# DRB CASE ACTION LOG

DRB Application No.: 03-00528 (P&F)	Project # 1002021
Project Name: ONE PRESIDENTIAL PLAZA	EPC Application No.:
Agent: Tierra West LLC	Phone No.: 858-3100

**SUBJECT: One Presidential Plaza/preliminary & final plat**

Plat of
 Lots E-2-A-1, E-2-A-2 and E-2-A-3
One Presidential Plaza
 Albuquerque, Bernalillo County, New Mexico
 December 2002

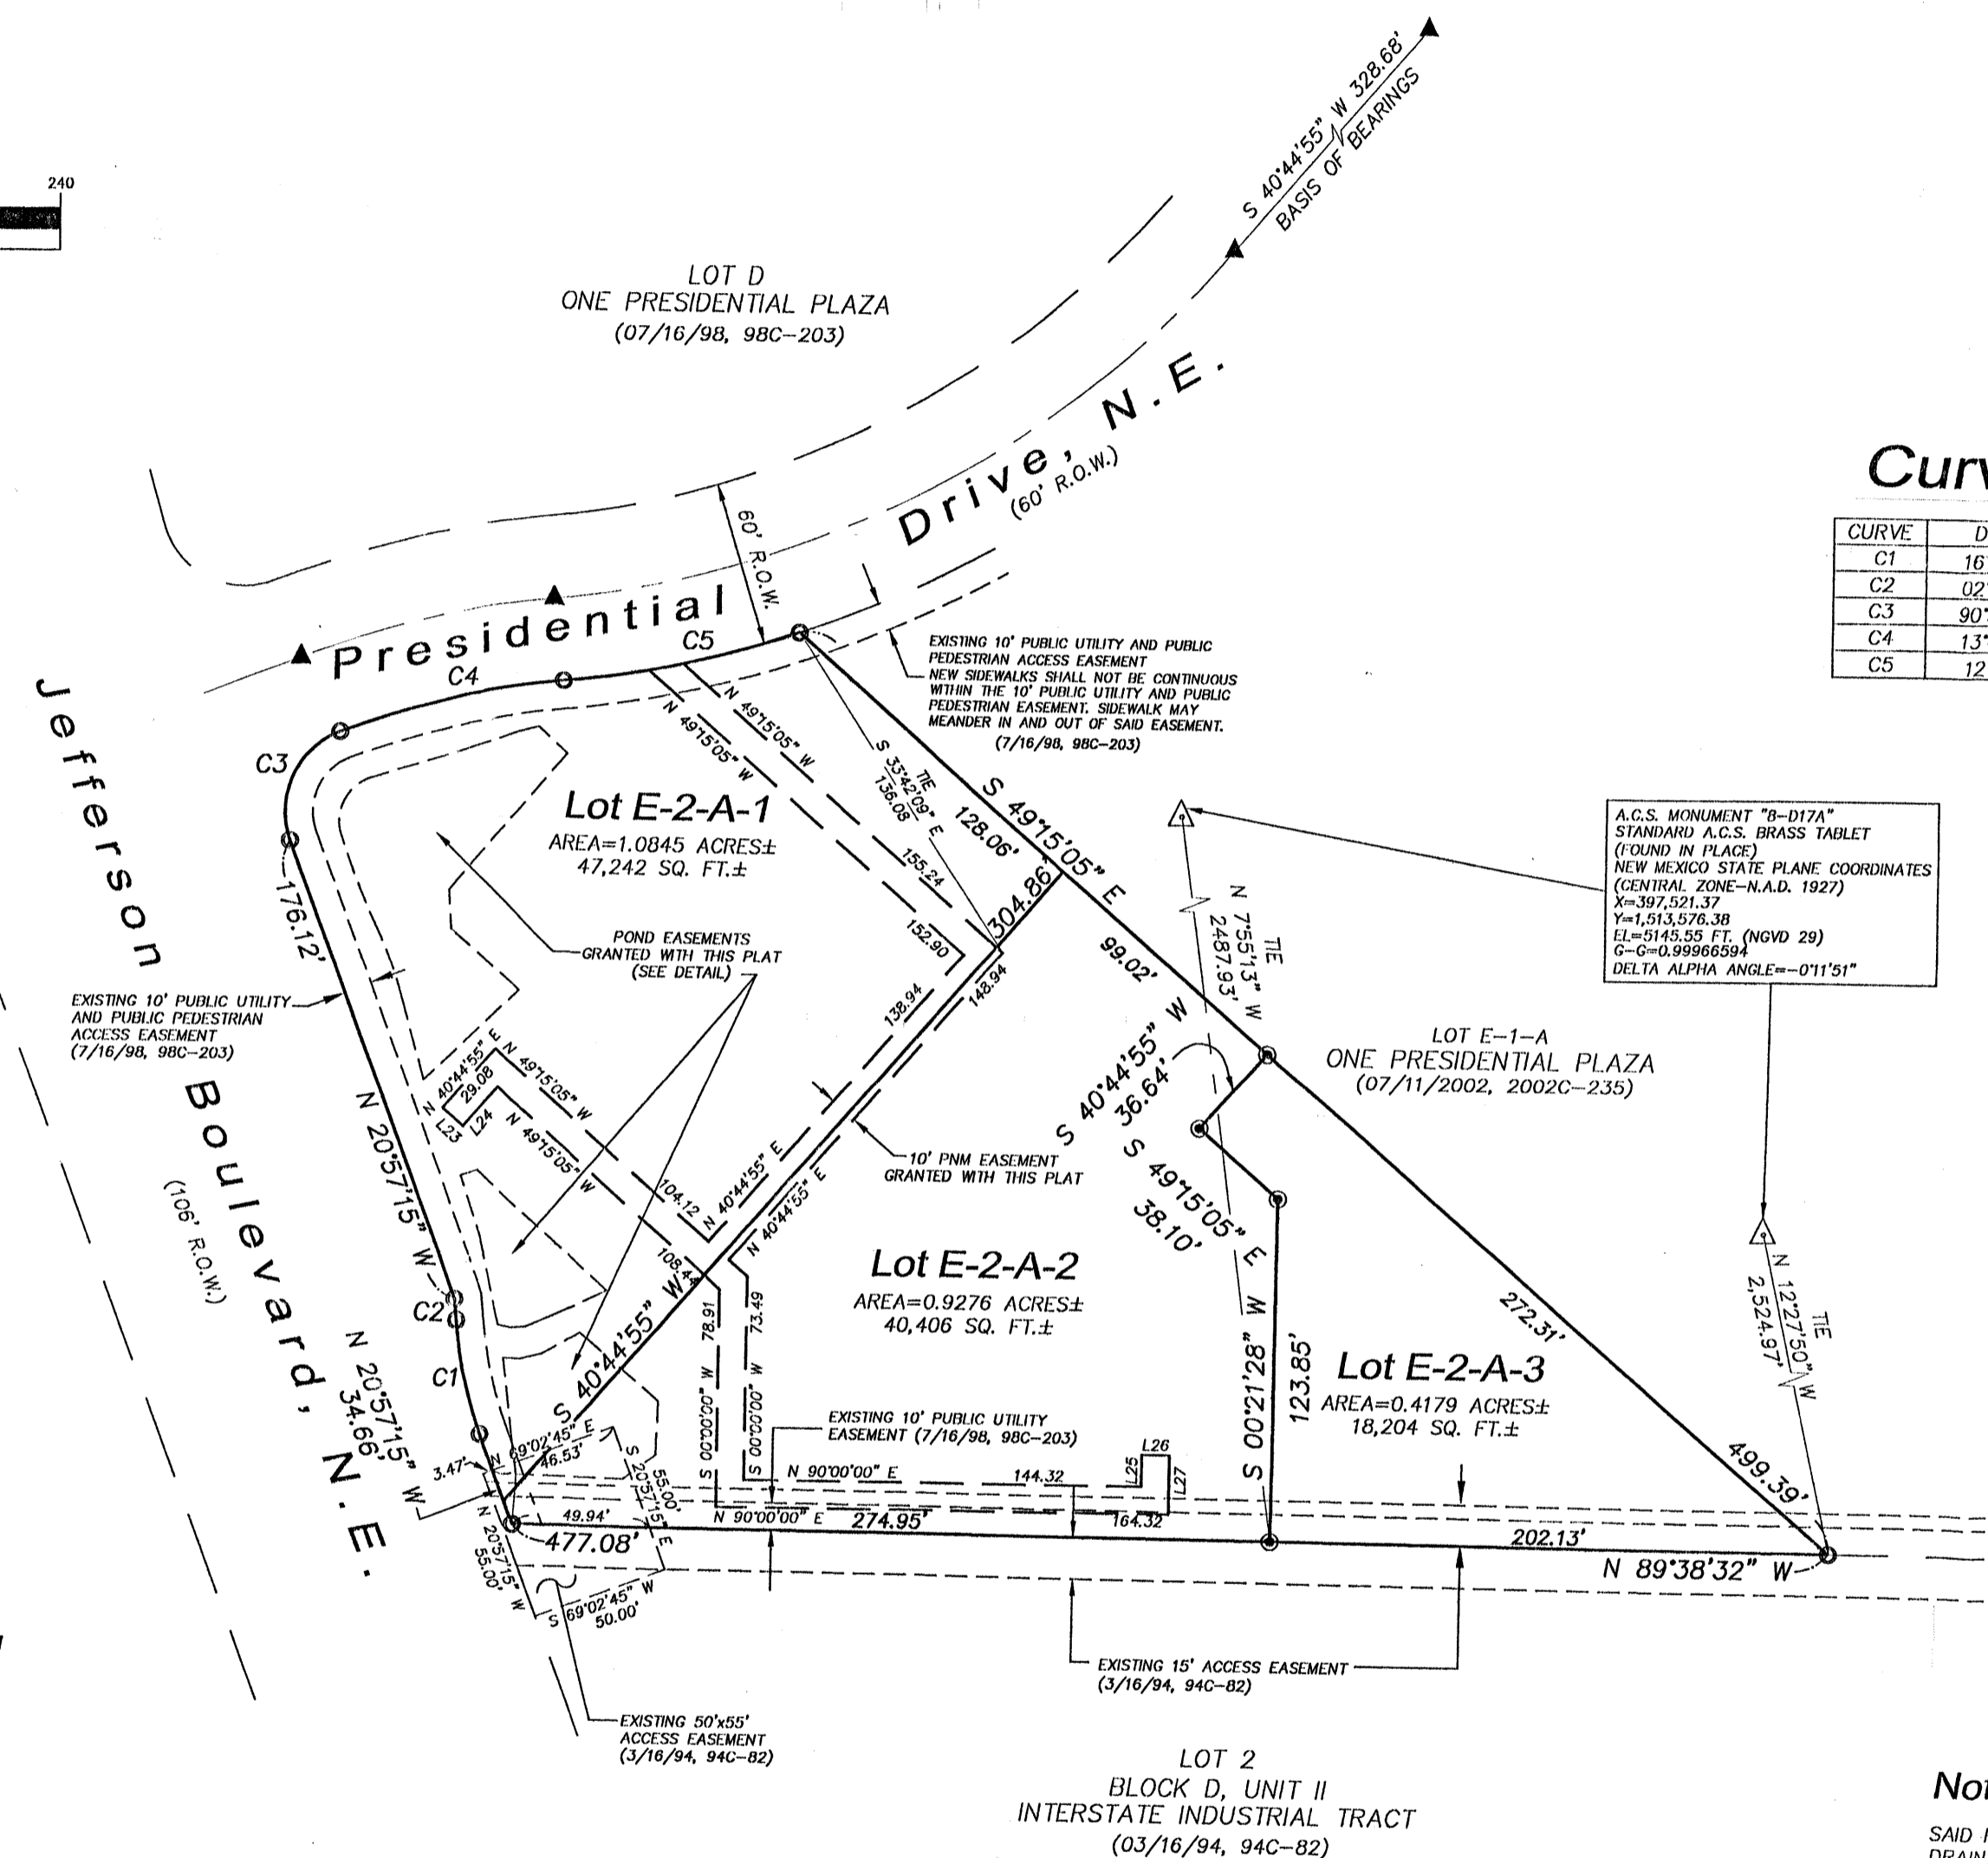
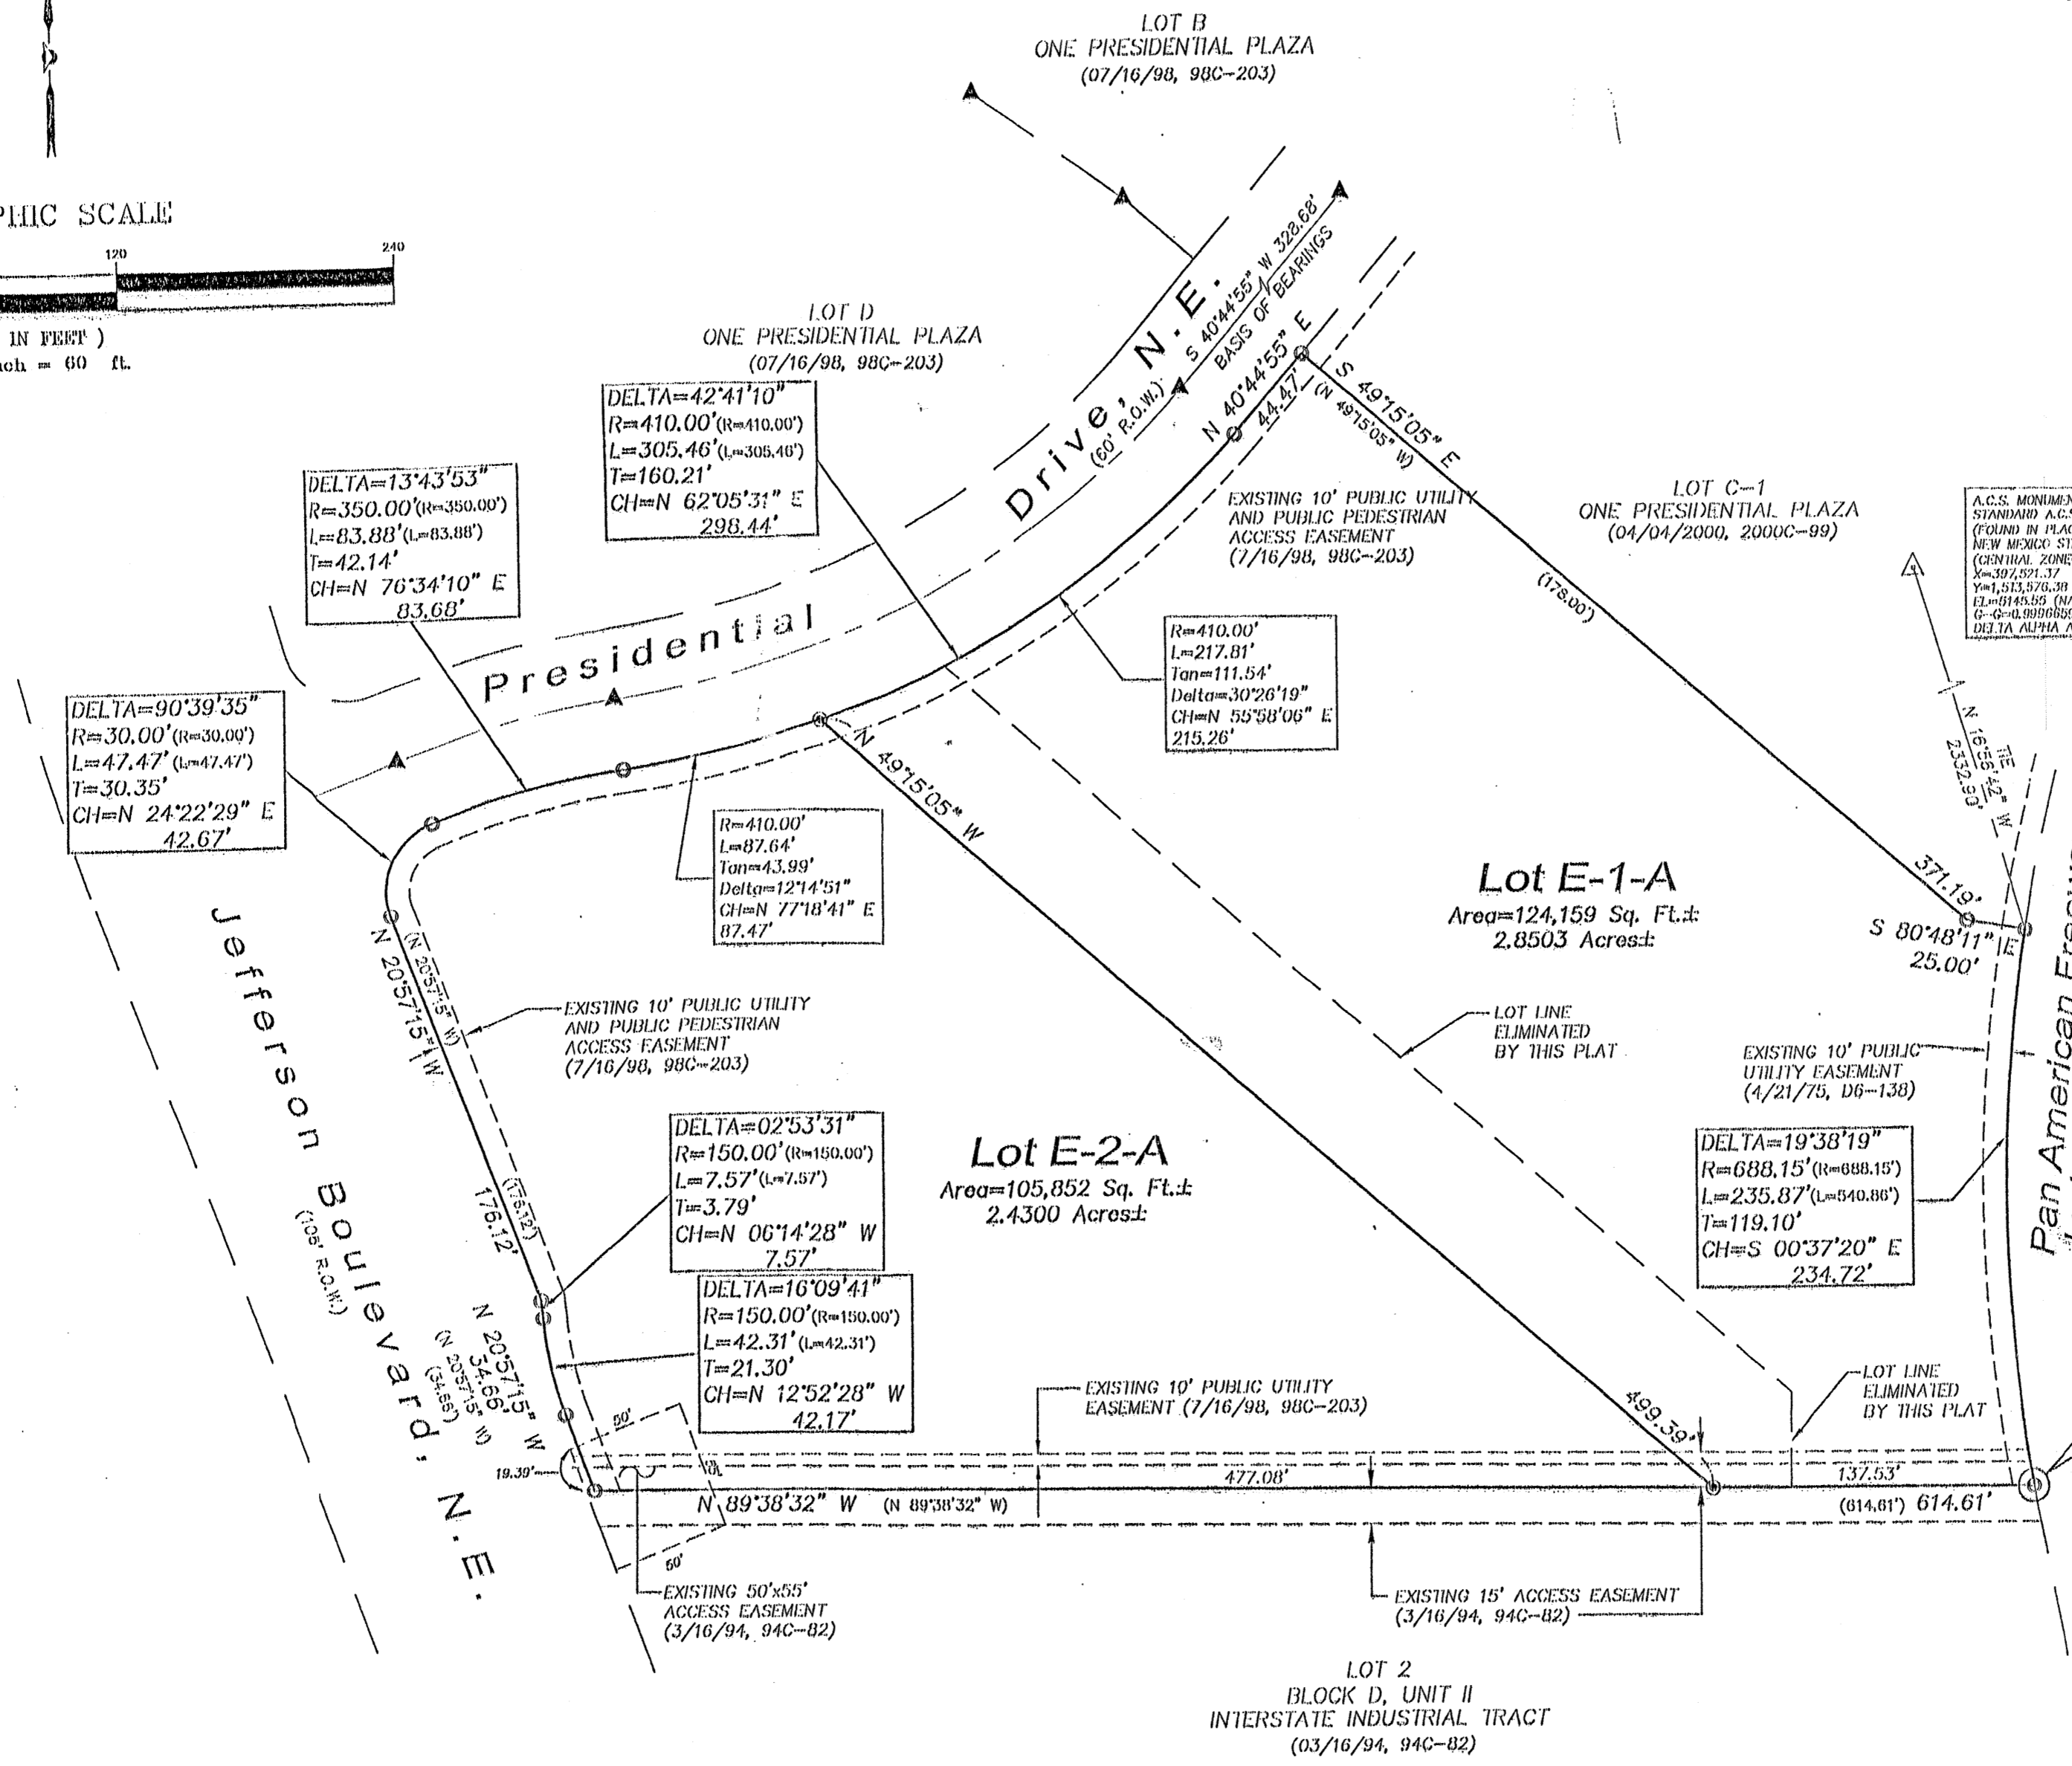
UTILITIES: - need private water/sewer easements on plat Done

- need shared sewer Agreement Done

- verify that there is account for private fire hydrant Done

UTILITIES: - need private water/sewer easements on plat  
 - need shared sewer Agreement  
 - verify that there is account for private fire hydrant

ENGINEER'S SEAL	ONE PRESIDENTIAL PLAZA	DRAWN BY B/JF
	TRAFFIC CONTROL LAYOUT AND SITE PLAN	DATE 12/18/02
RONALD R. BOHANNAN P.E. #7868	TERRA WEST, LLC 8509 JEFFERSON NE ALBUQUERQUE, NEW MEXICO 87113 (505)858-3100	22060TCL-SP.DWG
		SHEET # 1
		JOB # 220060

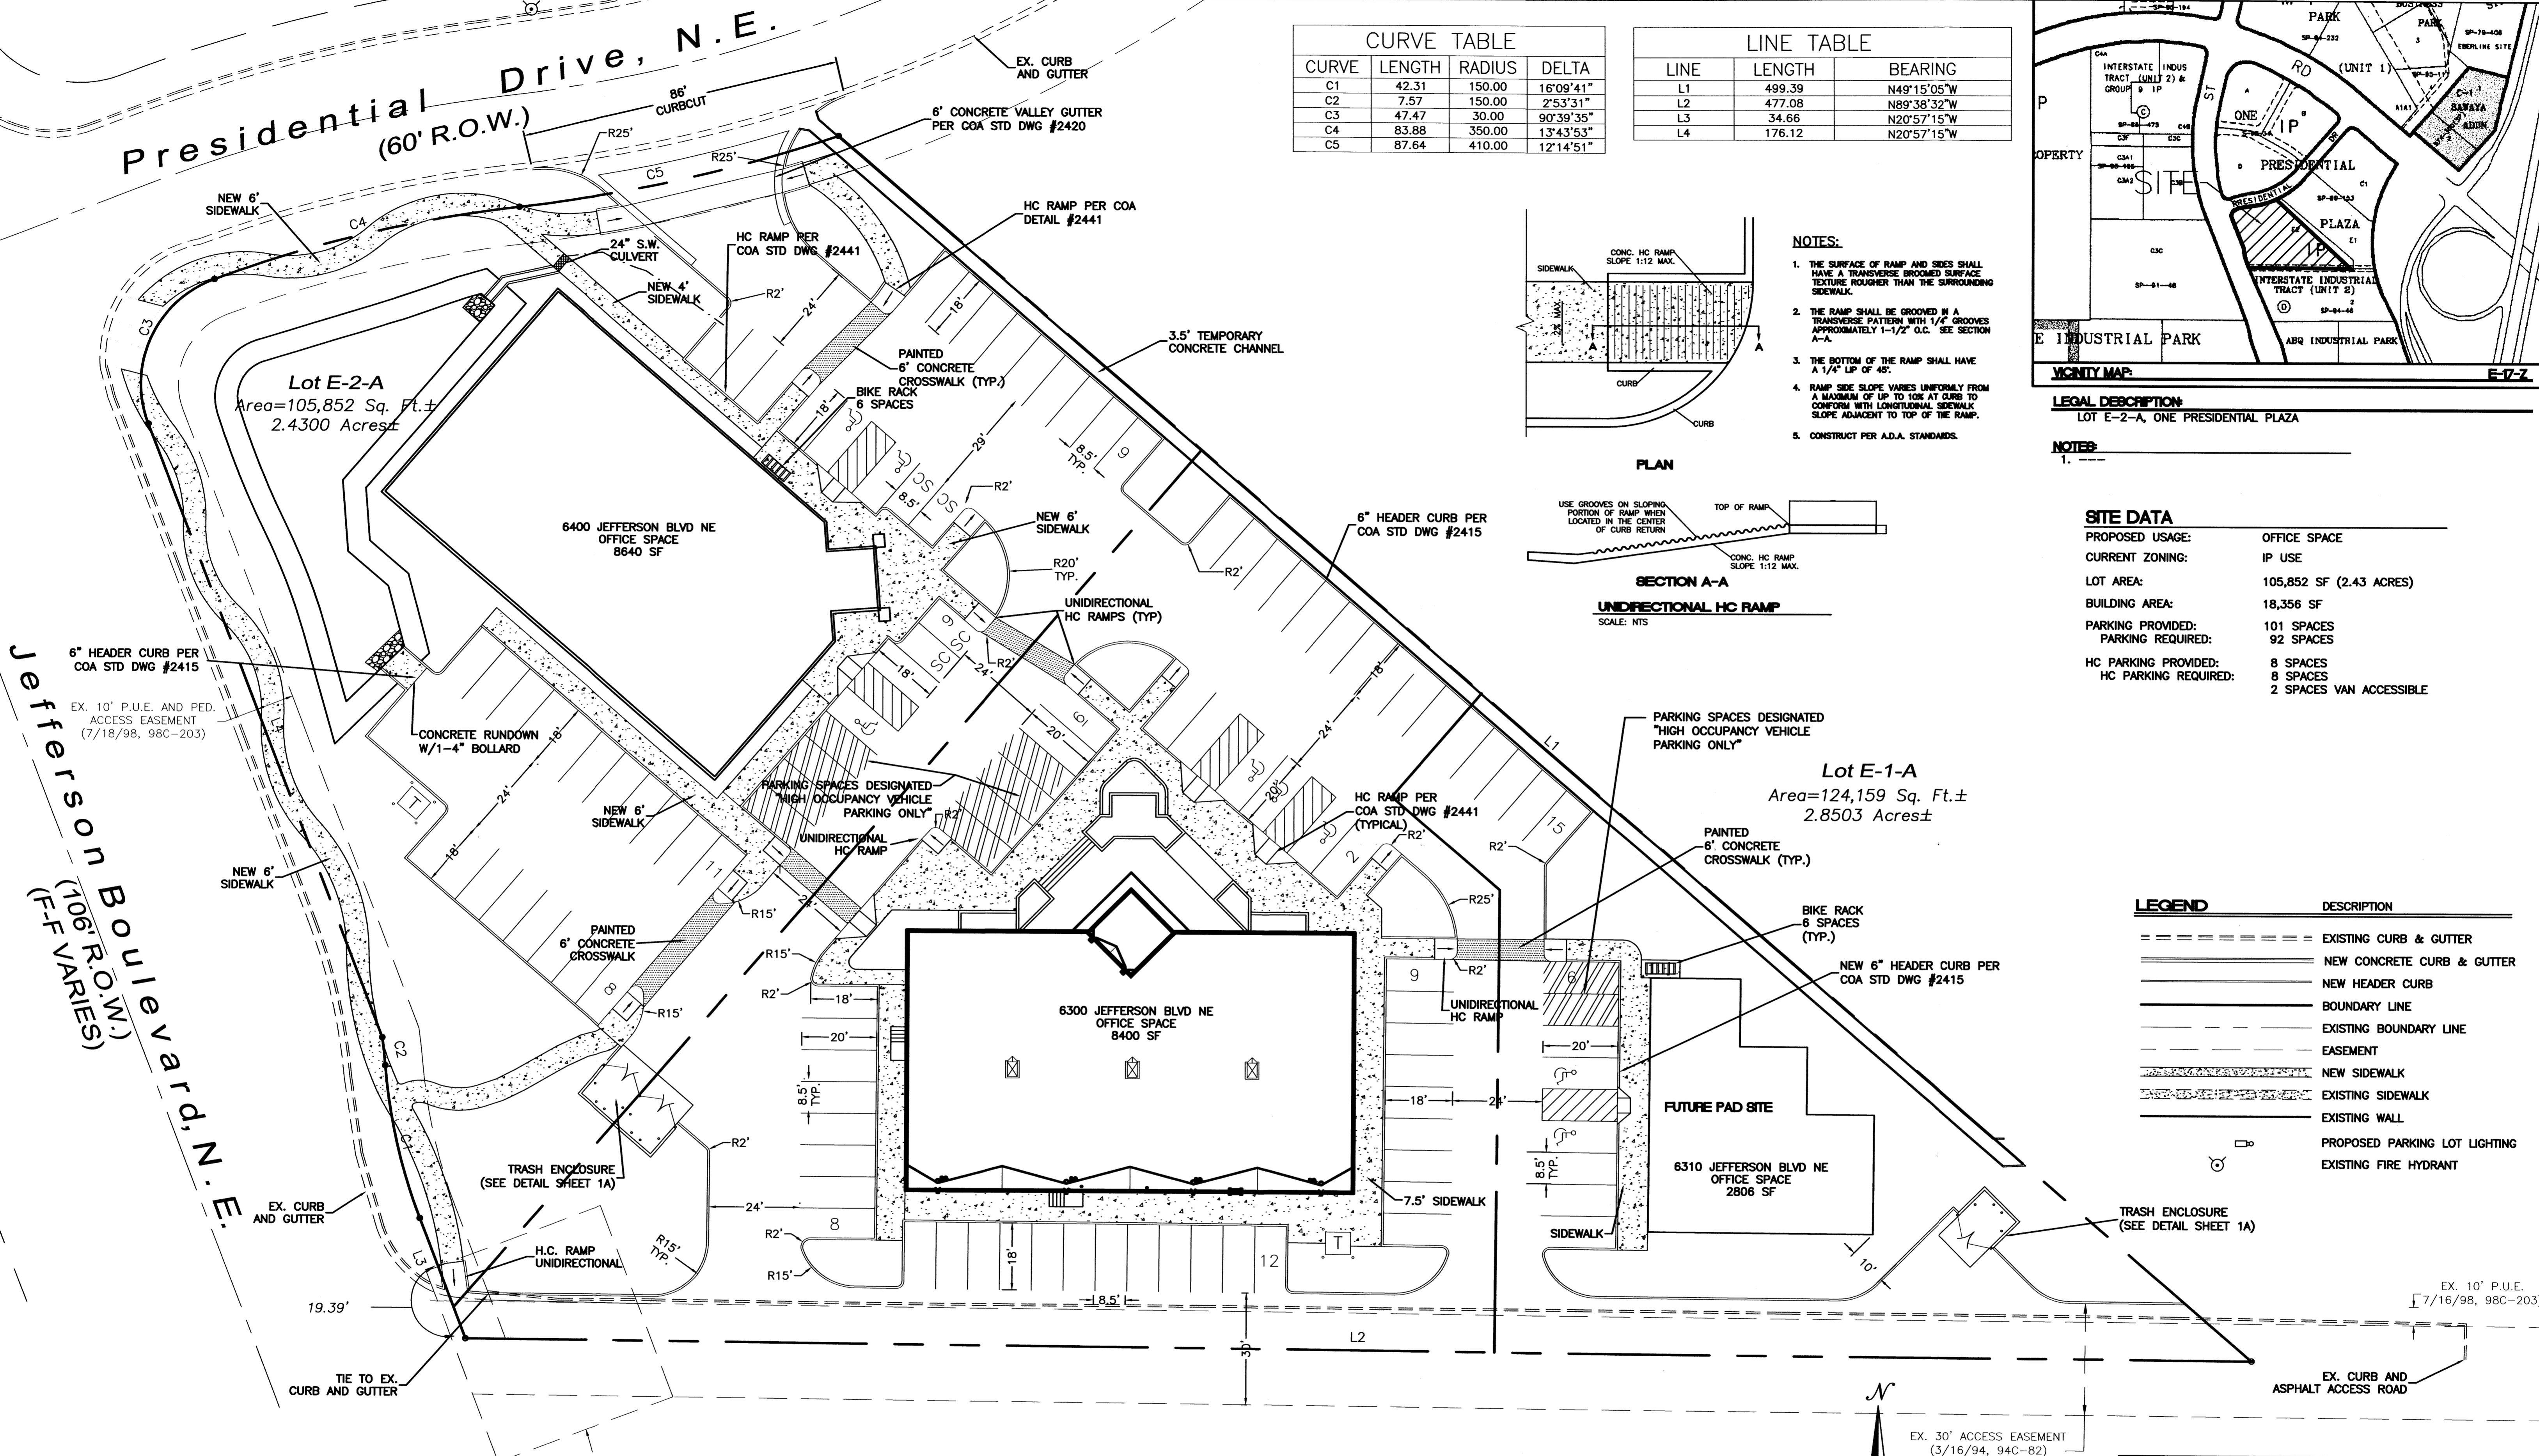
<b>TRANSPORTATION DEV (505) 924-3990</b>		
PLANS DISAPPROVED	DATE 7-2-03	DATE
PLANS APPROVED	DATE 7-03-03	DATE
COMMENTS:		
NEED SITE PLAN / sketch showing Property Lines & PARKING LAYOUT		
7/3/03 JW (BF) SP + TCL w/ Property Lines JFM

No.	Comment
<input type="checkbox"/>	A site plan is needed. Do these new lot lines conform with the site plan for subd/building permit?
<input type="checkbox"/>	How is access addressed for these three lots?
